Yorkshire Green Energy Enablement (GREEN) Project

**Document 5.3.6B ES Chapter 6 Appendix 6B - Technical Engagement
on Landscape and Visual Assessment**

Planning Inspectorate Reference: EN020024

Viewpoint 9: Track to Newlands Farm

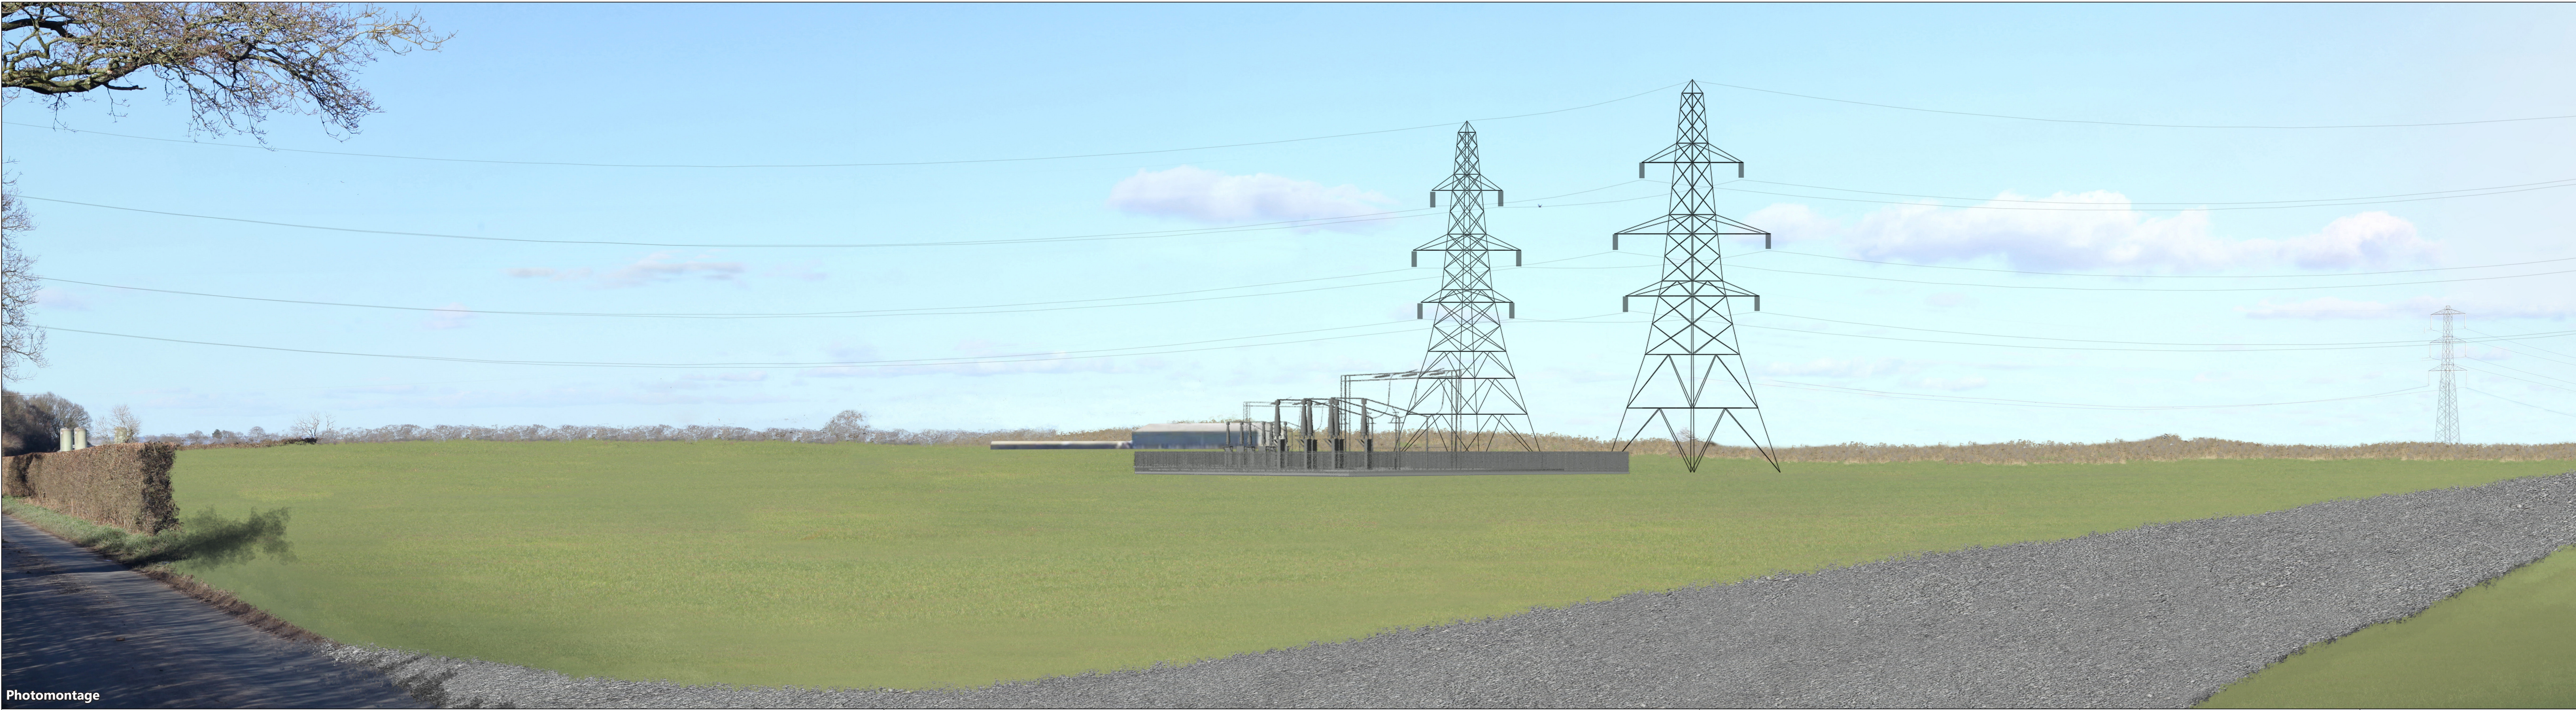
3	<p><u>Viewpoint and Visualisation selection</u></p> <p>NF asked consultees for specific feedback on the viewpoints proposed at PEIR (none was provided on the call). NF described the proposed changes to the Viewpoints 9 and 24 which were agreed in principle by JW. The revised locations for these views are provided in the screen grab plan extracts below.</p> <p>Viewpoint 9 –Other Route with Public Access close to the Cable Sealing End Compound as indicated on the extract below (relocated from the PEIR location on Corban Lane to the east where intervening planting would restrict views of the Project).</p>	<p>Input needed by 10-03-22</p>
